Harnett County
420 McKinney Pkwy
LILLINGTON, NC 27546
Phone:
Fax:

SUBJECT: BRES2408-0025
BUILDING RESIDENTIAL

Here are the results of all Inspections located at **168 WILDWOOD WAY:**

SIDE VIEW

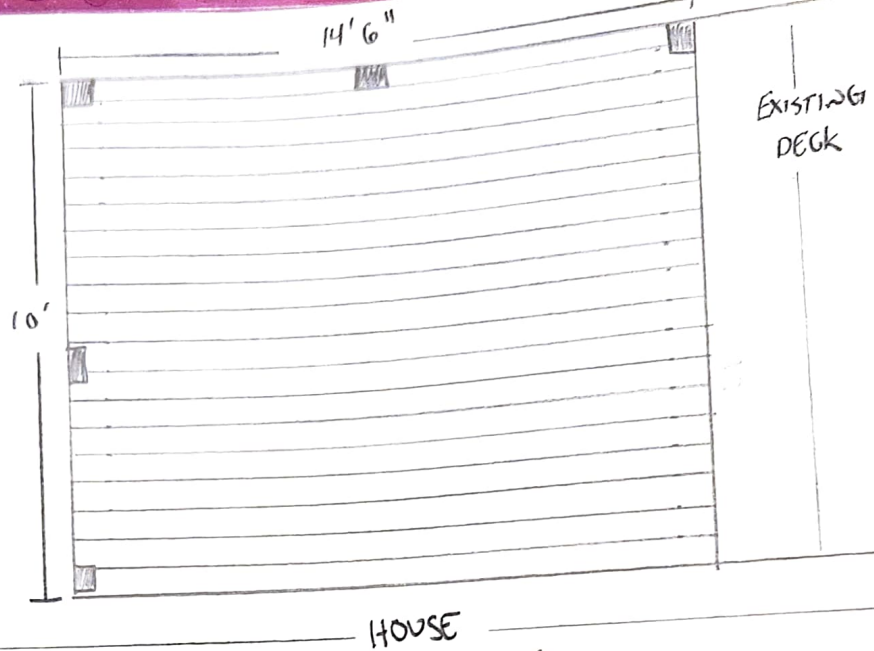
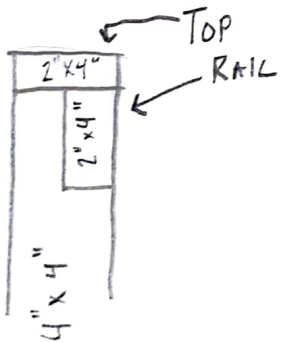
Inspection Type: FINAL**
Scheduled Date/Time: 10/8/2024
Completed Date/Time: 10/8/2024
Inspector: Ricardo D Honrada
Result: DISAPPROVED
Remarks:
Notes: Missing nails ledgers 6 inches apart. Need lugs bolts on the band and girder to the post. Need blocking on the stringers and lugs bolts.
